M42 Junction 6 Development Consent Order

8.16 Statement of Common Ground with National Exhibition Centre Limited

October 2019

EXISTING CADENT GAS LOCAL GAS GOVERNOR AND ITS ASSOCIATED CONNECTION TO BE DISCONNECTED. DISCONNECTION OF GOVERNOR SUBJECT TO DETAILED DESIGN STUDY BY CADENT.

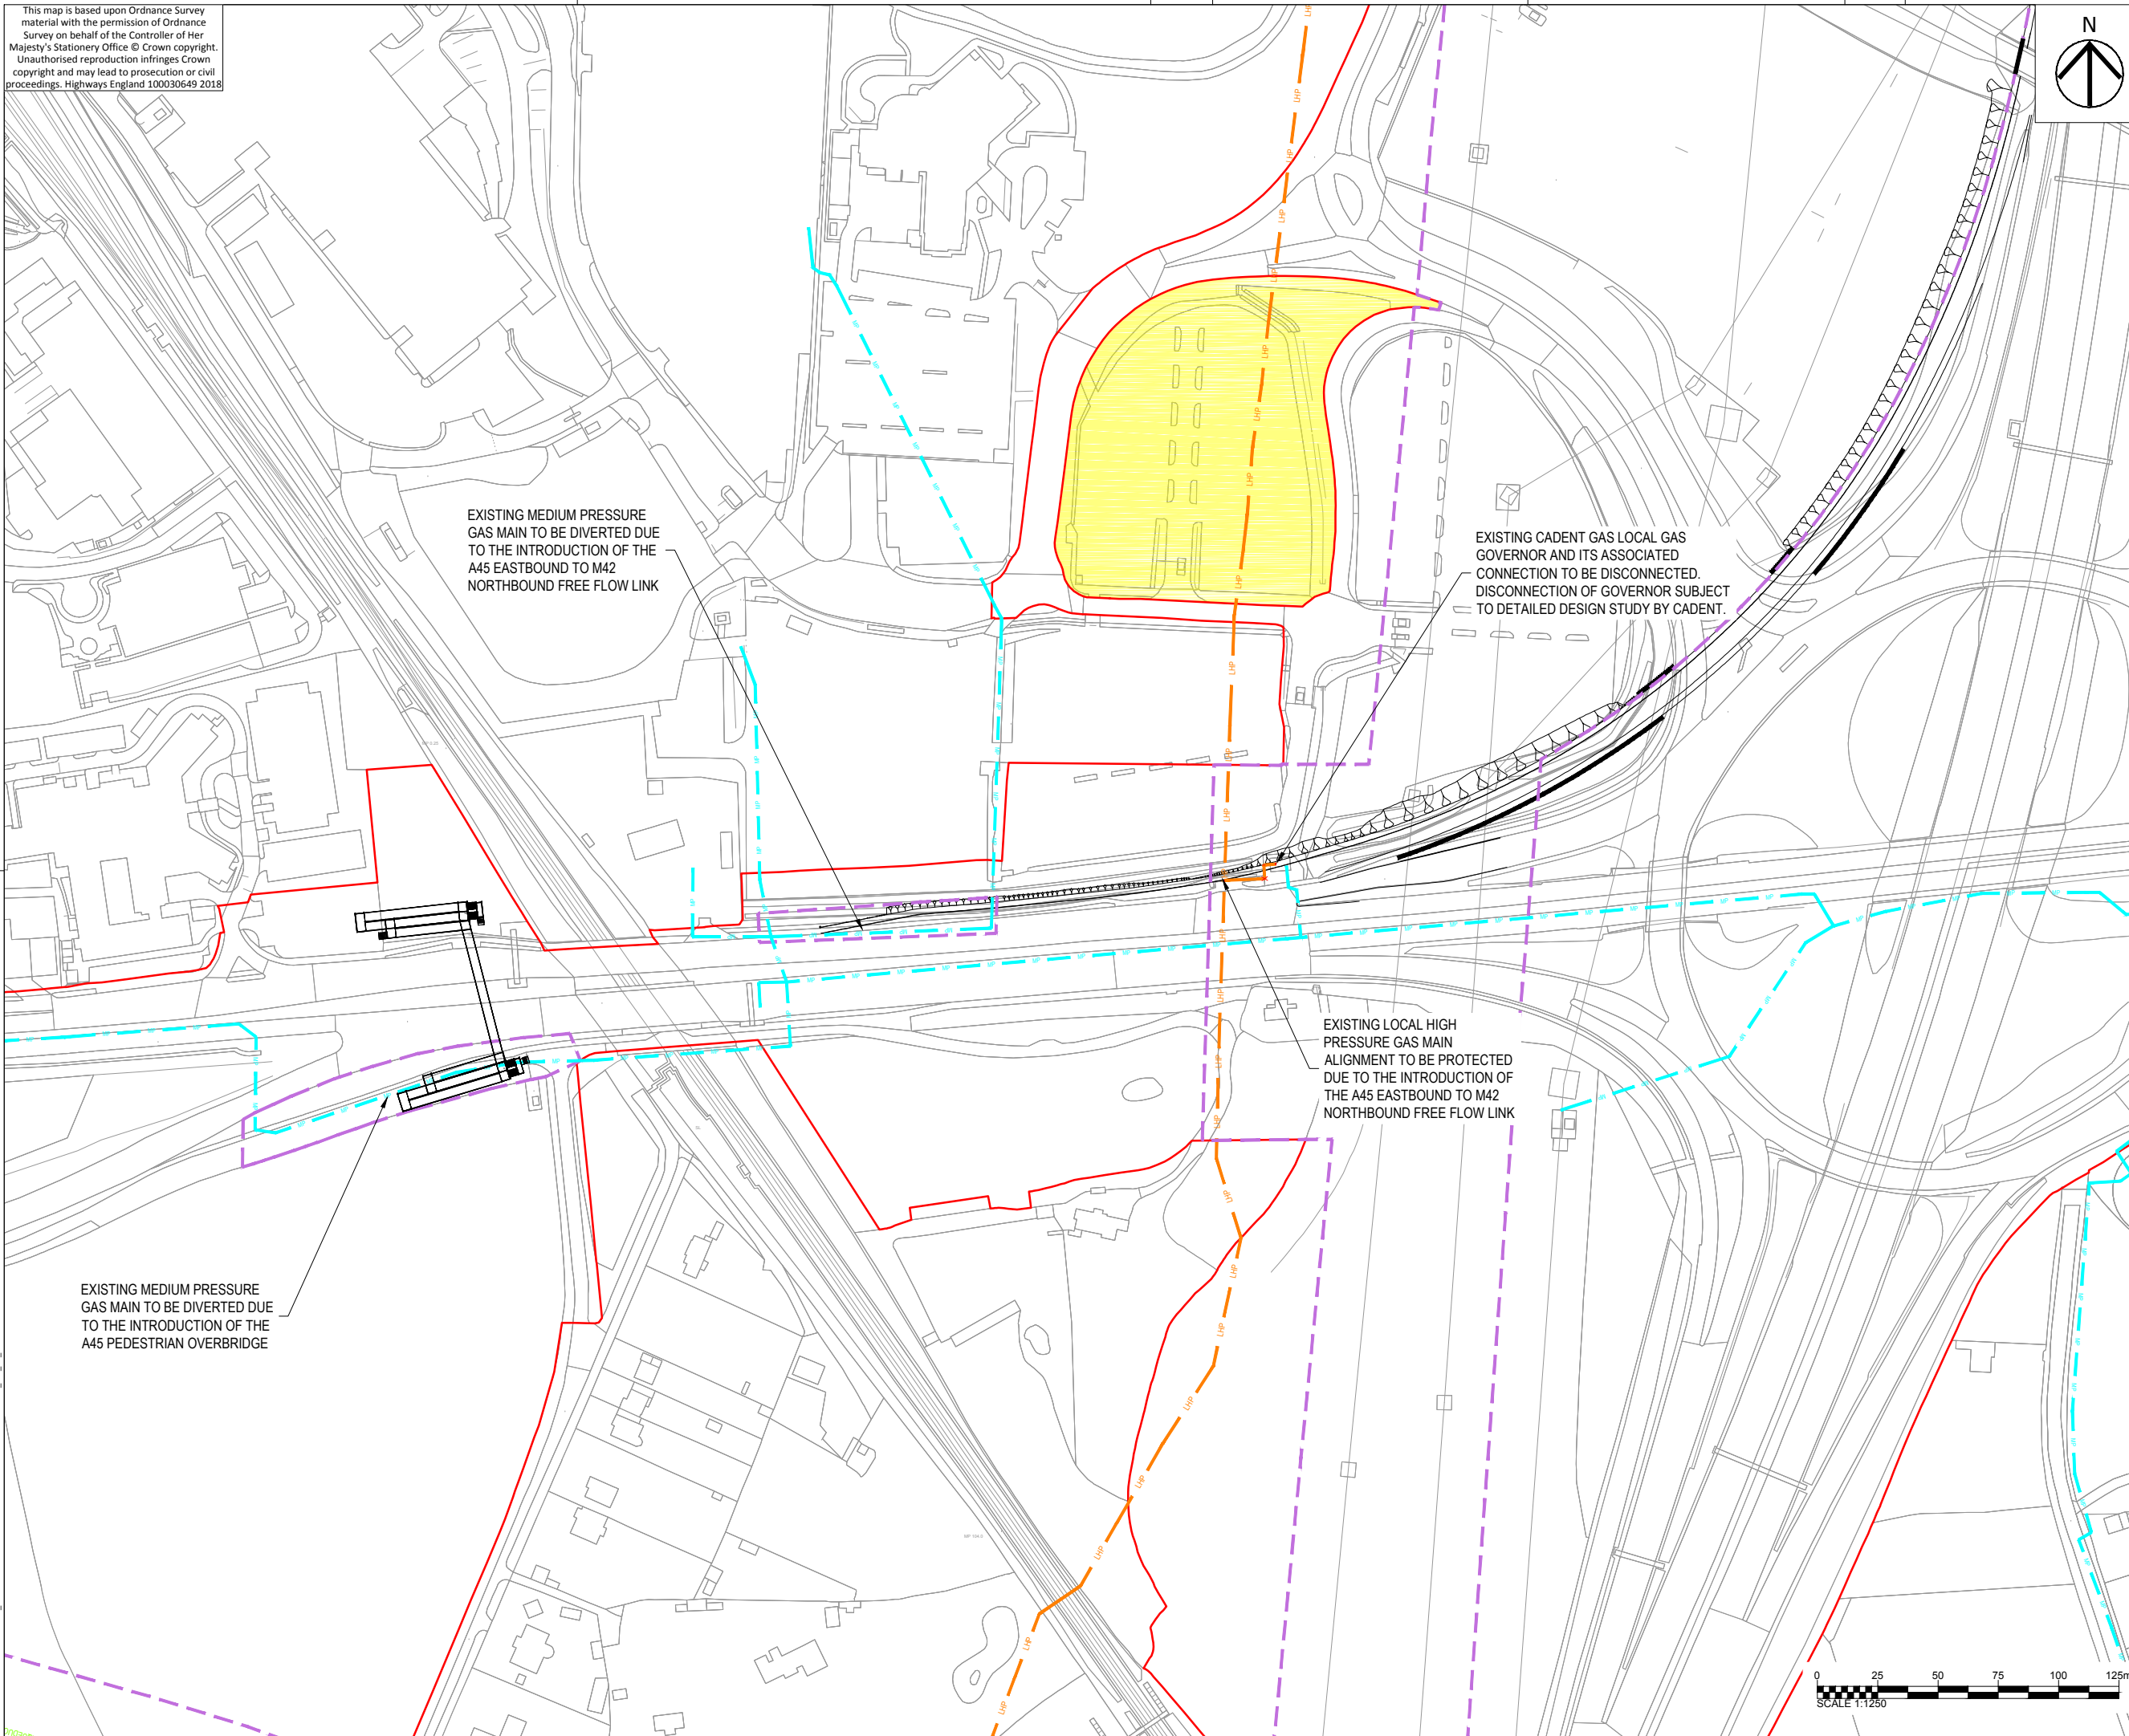
| Sub-topic | NEC Comment | Highways England Response/Actions | Status/Agreement |
|---------------------|---|---|------------------|
| Gas governor | The NEC queried whether the gas and electricity apparatus was to be impacted by the Scheme. | <p>It was previously expected that Cadent Gas would decommission its gas governor in the vicinity of the NEC.</p> <p>During recent discussions, Cadent Gas has advised that it will be retaining the governor and is therefore considering alternative locations for this to be situated. Discussions are underway with Cadent Gas to relocate the governor within the DCO powers and Order limits.</p> <p>In acknowledgement of the potential impact on the NEC's car parks, Highways England will use reasonable endeavours to ensure that Cadent Gas pursues the relocation of its gas governor as a result of the Scheme either off-site or outside of the NEC's retained land.</p> | Under Discussion |
